## **DC/23/1588/FUL**

Application Number: DC/23/1588/FUL

Address: The Arboretum The Park Great Barton Suffolk IP31 2RH

Proposal: Planning application - one dwelling

BLOCK PLAN

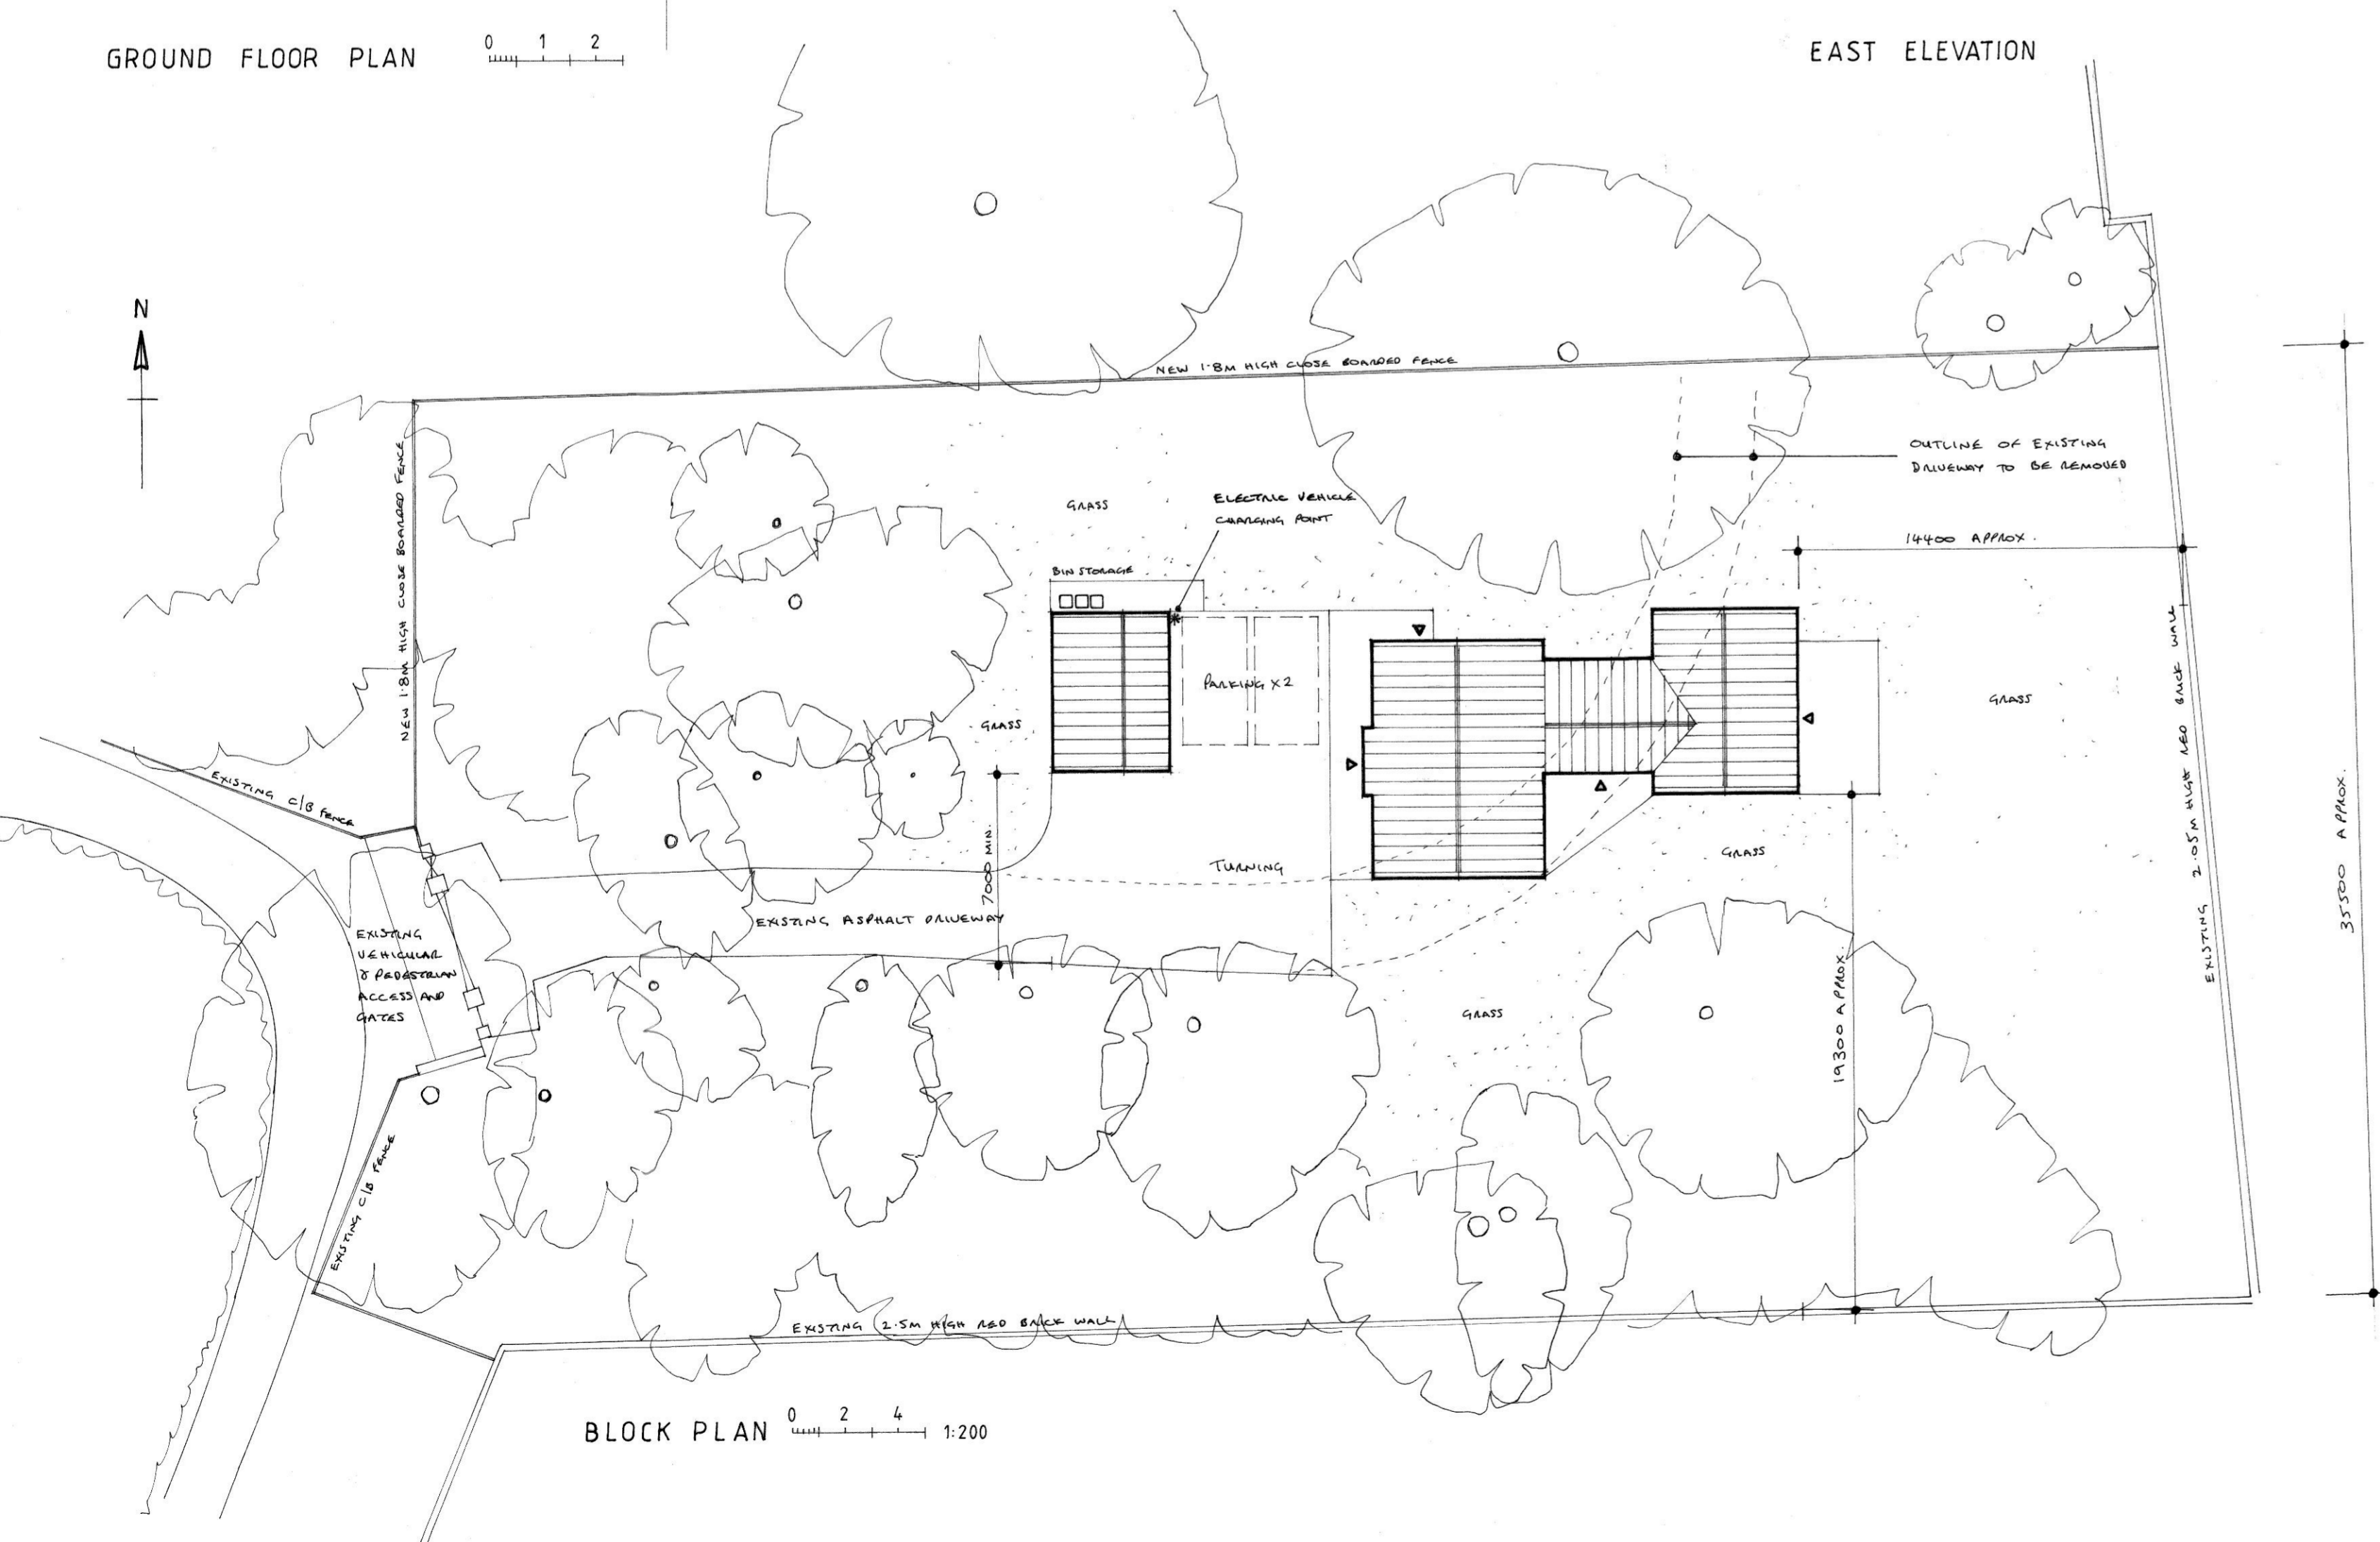
Suitable access will be required for waste collection. Please also provide bin collection points.
